## Online Comment

**Application** H12-0623-25  
**Location** Villa Farm Lutton Garnsgate Spalding PE12 9JP  
**Proposal** Change of Use of Agricultural Buildings to 5 Dwellings

SITE PLAN - EXISTING

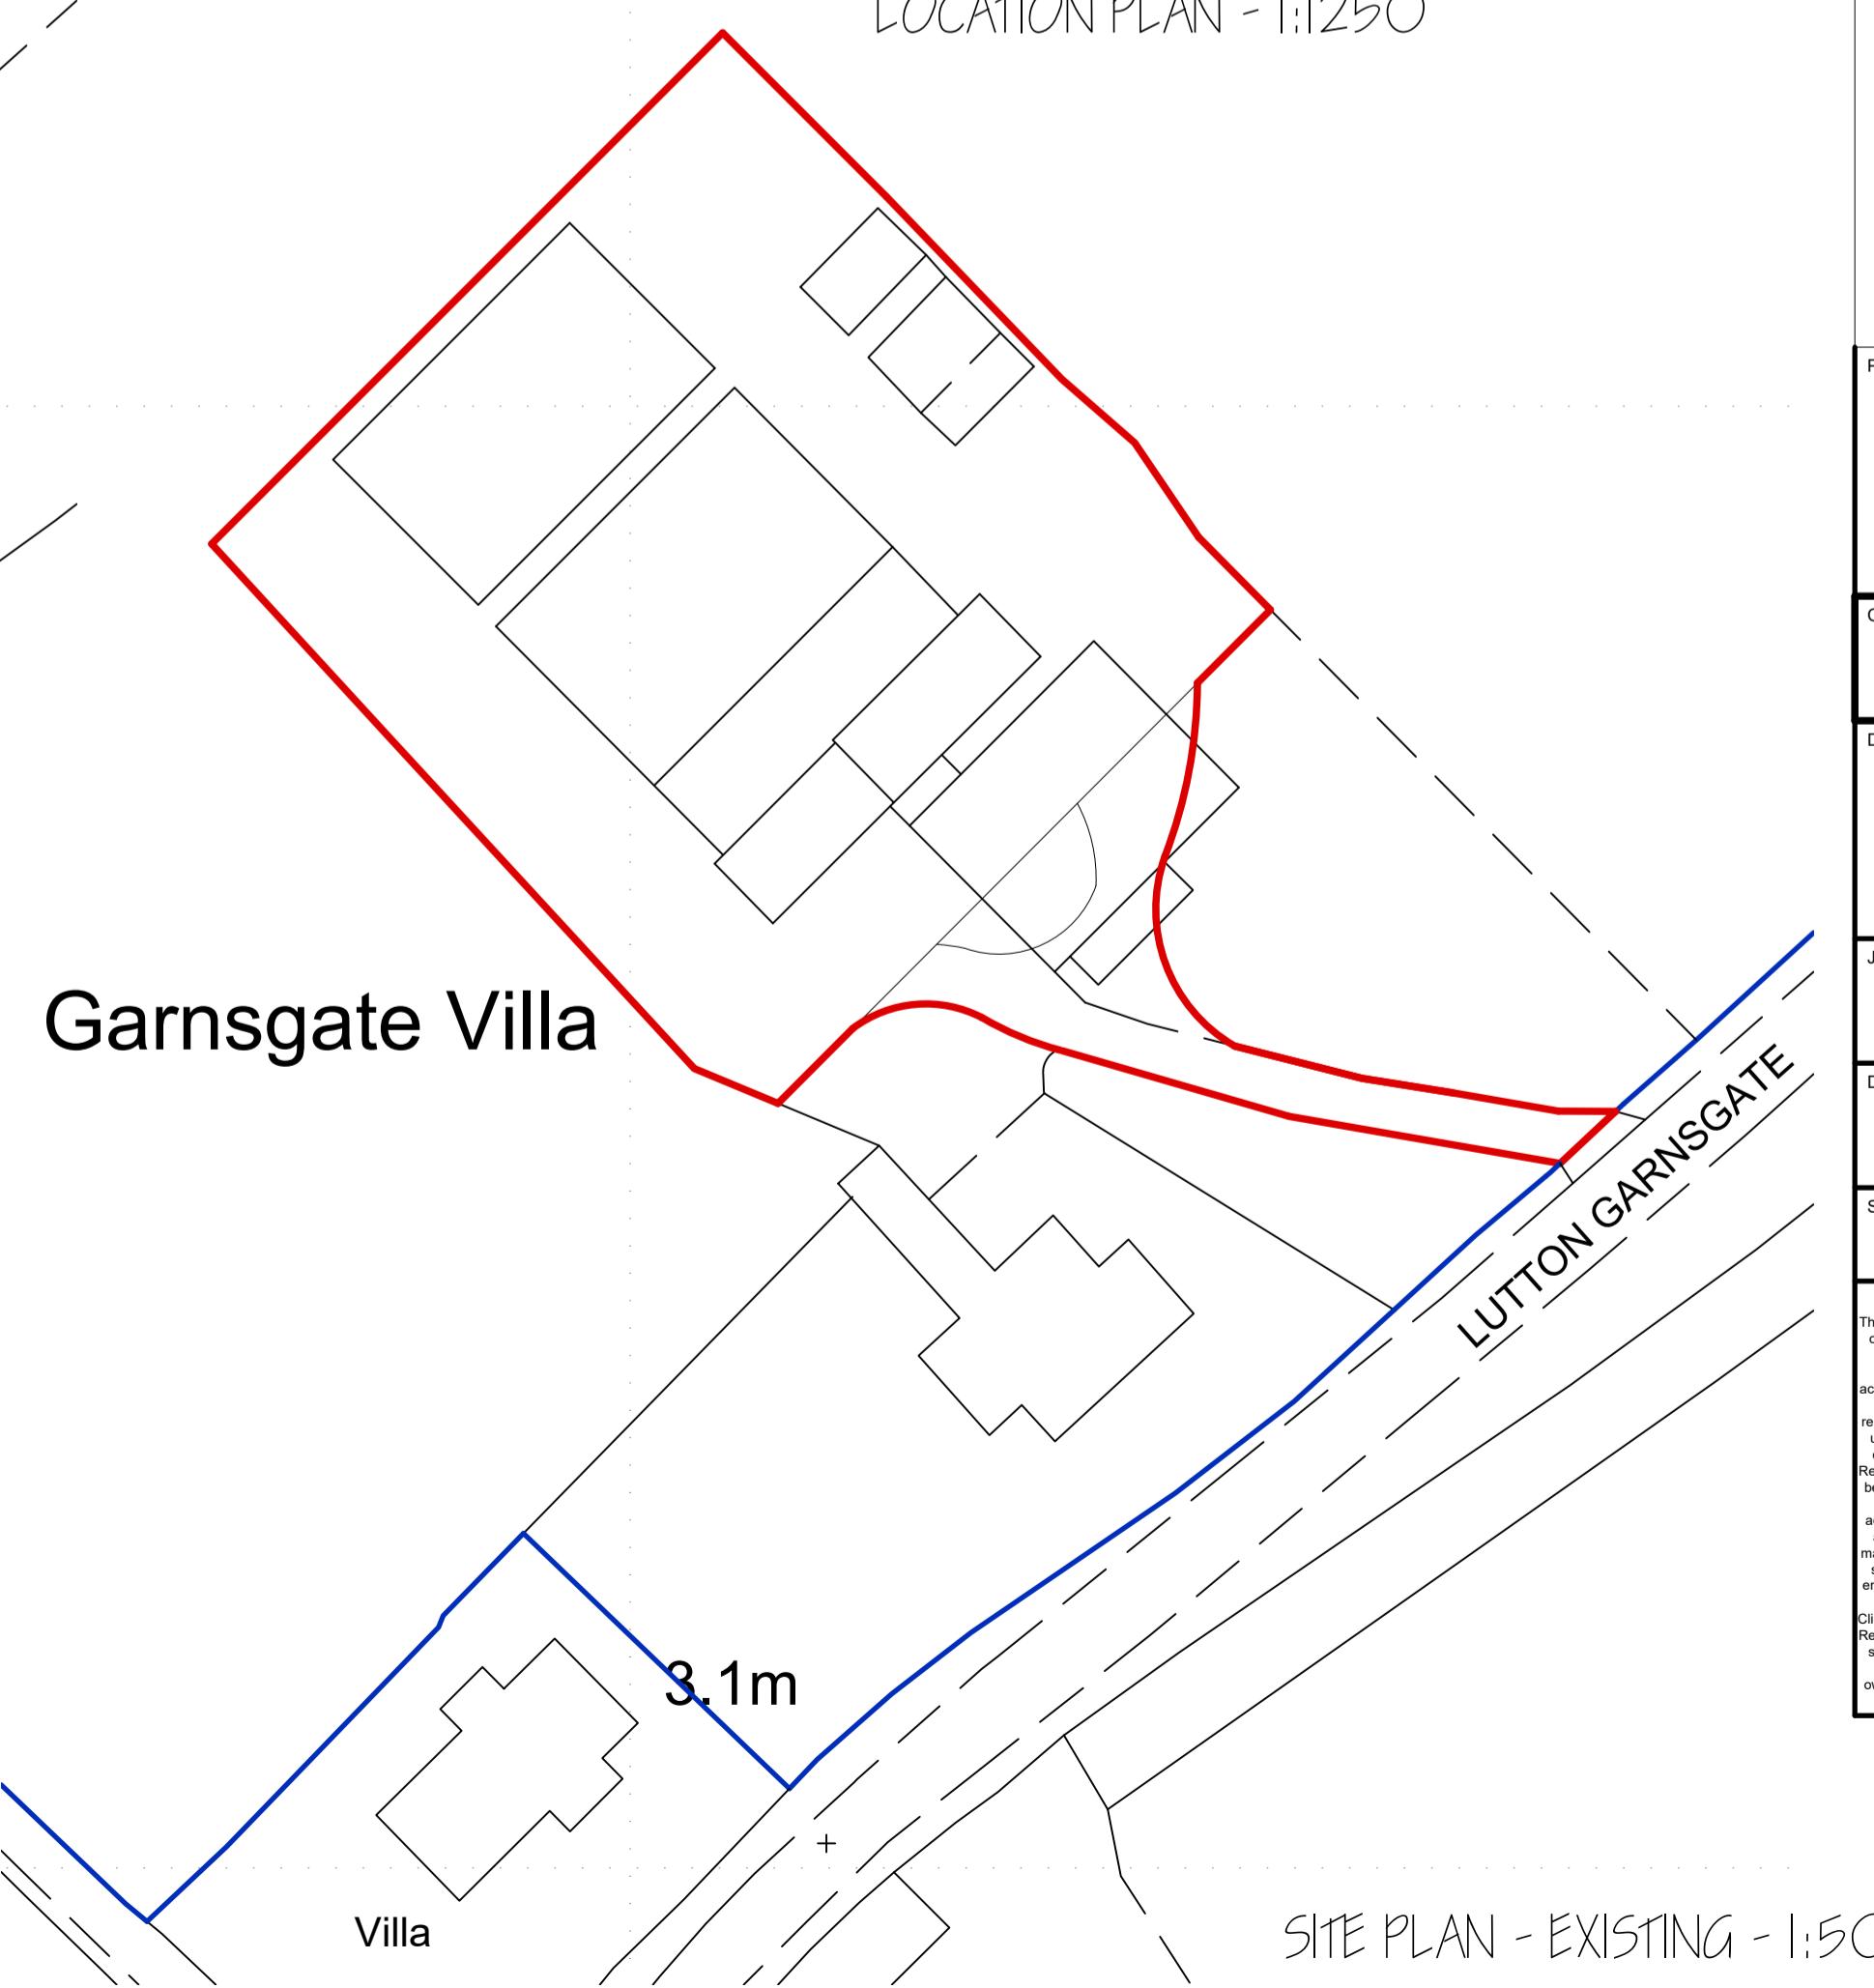
Please contact NGED on Tel: 105 regarding the O/H LV cable running across the drive entrance and the LV O/H cable running along the drive to the building in situ (Pole numbers 58968294 & 58968289)
